City of Portland, Maine - Building or Use Permit Application
 389 Congress Street, 04101 Tel: (207) 874-8703, Fax: (207) 874-8716

PERMIT ISSUED		Permit No: 02-0373	Issue Date: APR 23 2002	CBL: 339 G020001
Location of Construction: 28 Woodbury St	Owner Name: Lyons, Jason & Mary Tracey	Owner Address: 28 Woodbury Street	Phone: 878-9152	
Business Name:	Contractor Name: Applicant	Contractor Address: Portland	Phone:	
Lessee/Buyer's Name	Phone:	Permit Type: Additions - Dwellings	Zone: R-3

Proposed Project Description:
Construct 14' x 16' Deck

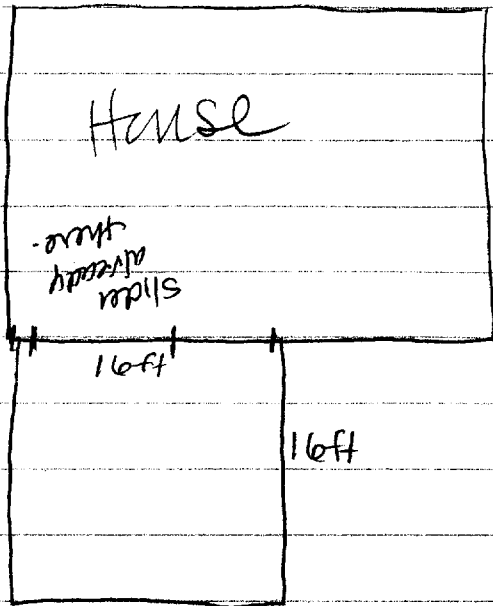
36" Guards with openings less than 4 " must be installed on both sides of stairs

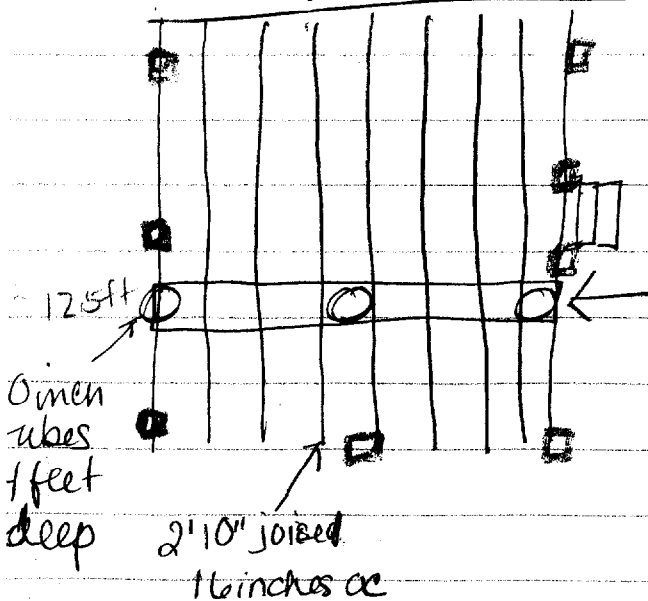
The rim joist must be properly affixed to the structure and joist hangers or a ledger must be utilized.
This Plan must be submitted and approved prior to commencement of framing.
